**KIRKLEES METROPOLITAN COUNCIL
INVESTMENT & REGENERATION SERVICE**

**DELEGATED DECISION TO DETERMINE APPLICATIONS FOR
NON-MATERIAL AMENDMENTS**

Reference No: **2026/NM/91176/E**

Site Address: land at, St Luke's, Bierley Marsh, East Bierley, BD4
6PL

client name		Owens Developments Ltd	
project		New Dwellings - Land at St Lukes.	
drawing		House Type A : Terrace North and West Facing Elevations	
project number	19/157	plot date	24/11/20
		scale	1:100
drawing number	105	rev	B
		issue status	Planning Submission

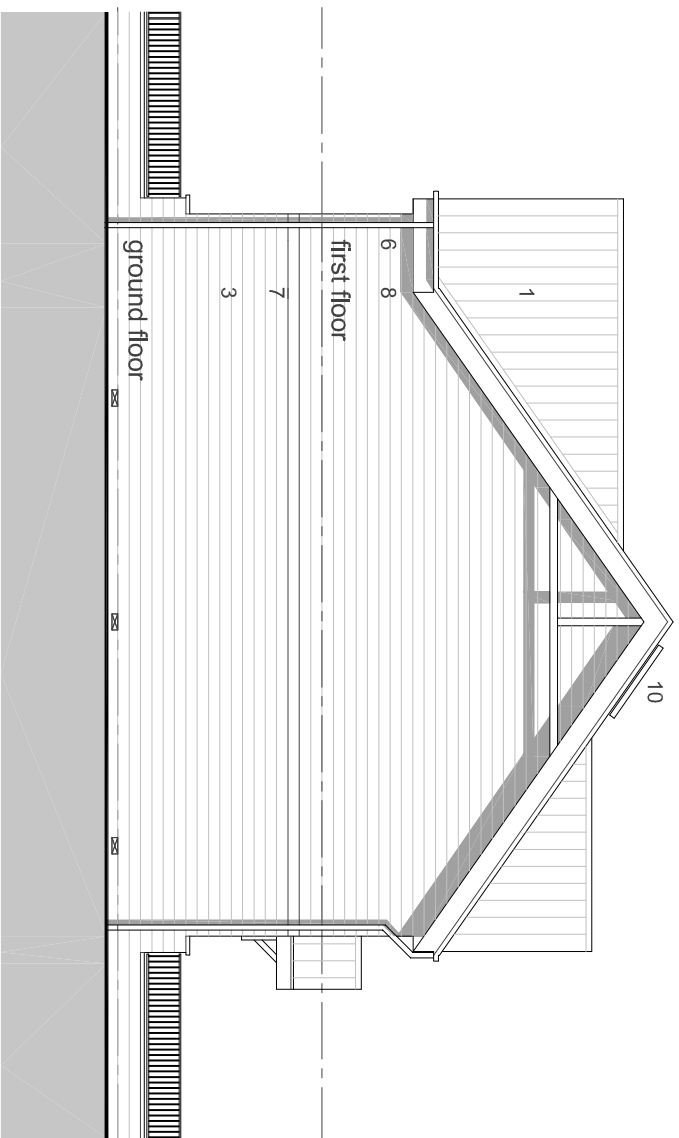
Insufficient details have been provided at this stage in relation to the design and projection of the proposed solar panels. It is acknowledged by officers that solar panels could be added to the properties as permitted development; however, officers consider the General Permitted Development Order has parameters to control the visual impact of solar panels which the details provided do not demonstrate. As such, a more detailed assessment would be required to determine any impact.

Visually, the addition of solar panels would be different to the original planning permission and as discussed above, the details provided do not provide sufficient information for officers to understand and assess the extent of the solar panels and any subsequent impact. An appropriate and thorough assessment beyond the scope of this application is therefore required

- The proposed changes would have likely been approved had it formed part of the original application – **Officers would not have approved the details as submitted. Further information would have been required in terms of the details of the solar panels and their affixing in order to assess the impact of any harm to the character of the properties and the surrounding area.**

- The proposed changes should not require a further restriction to make them acceptable – **Officers would need to restrict the projection of the solar panels beyond the roof plane.**
